Permit Number: 080098

has permission to Build Garage with unfinished space above for the bedroom

RE: 108 Cobb Ave. – 210-B-013 & 014 – R-2 Zone – permit application #08-098

ALIMADOV RESIDENCE

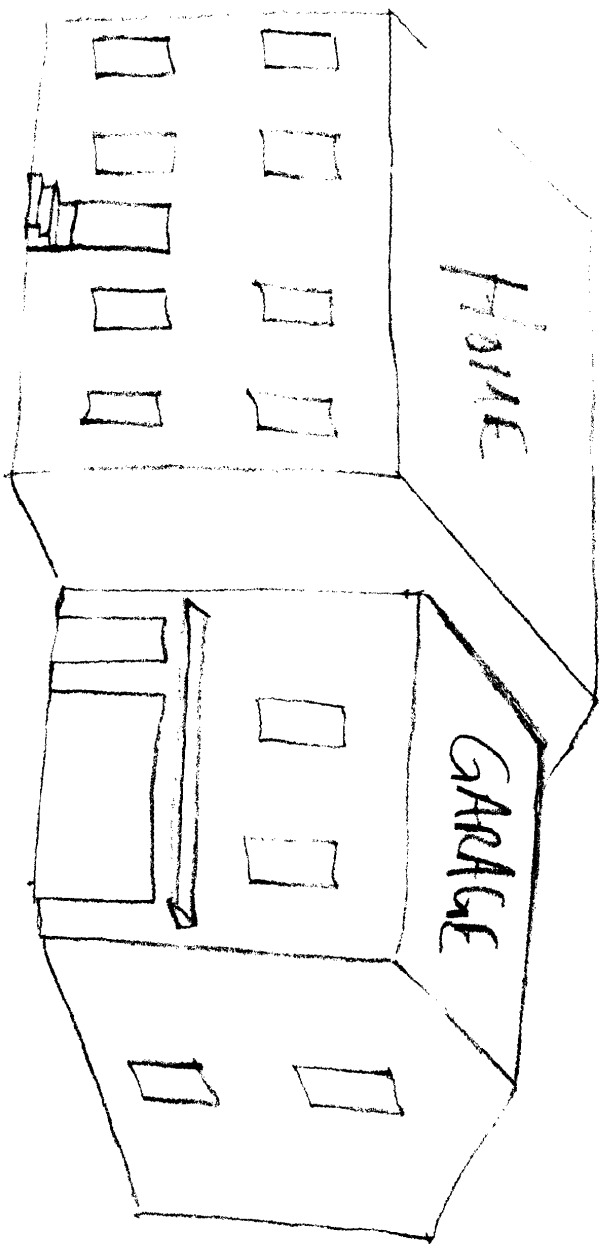
I am in receipt of your permit application to construct a new 24' x 24' garage. Before this office can issue your permit for the garage, it will be necessary to apply for permits for the deck and bulkhead on the rear of the new dwelling unit. The rear deck and the bulkhead were specifically deleted from the final building permit application on 3/10/07 by the contractor, Dwight Brackett.

See letter - The Deck & Bulkhead must be permitted prior to this issuance
24'± per code plans
